## CAMPBELL'S RIDGE COMMUNITY - LOT 25

Middleton Model — Elevation 10

### Crawl Space Piers

*Structural Drawings dated 02/08/2025, prepared by Mulhern + Kulp*

SD1

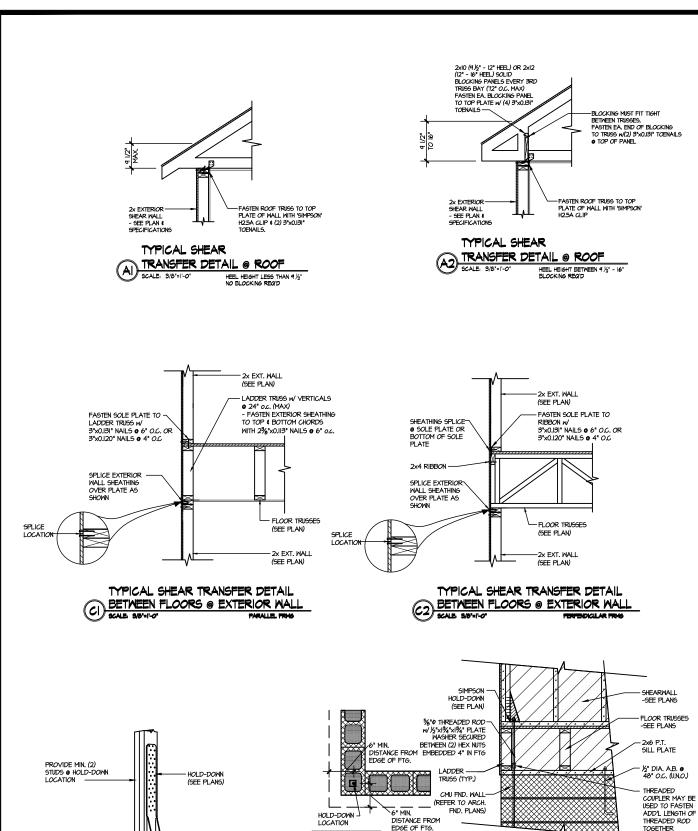
Pursuant to your request, we have prepared this letter to address the 1<sup>st</sup> floor framing of the above referenced lot. It was reported to us, by you, that the CMU piers were constructed for 2x12 beams instead of 2x10 beams; therefore, they were approximately 1 ½" too short. It was also reported to us, by you, that to make up this difference, an extra 2x sill plate was added to the top of the pier. Therefore, each CMU pier has (2) 2x P.T sill plates on top of it to support the dropped 2x10 girders. It is our understanding that these plates do not have the Simpson MAB23 mudsill anchors installed as shown in detail 8/SD1.0.

We have analyzed this as-built condition and it is our professional opinion that the additional 2x sill plate is structurally adequate to support the code required loads. At each CMU pier, the dropped girder shall be fastened to the (2)2x sill plates with (4) ¼" diameter x 4 ½" long Simpson SDS toe screws, and the (2)2x sill plates shall be fastened to the top of the CMU pier with (3) ¼" diameter Tapcon screws with 1" minimum embedment into the CMU pier. See the attached redlined detail for more information.
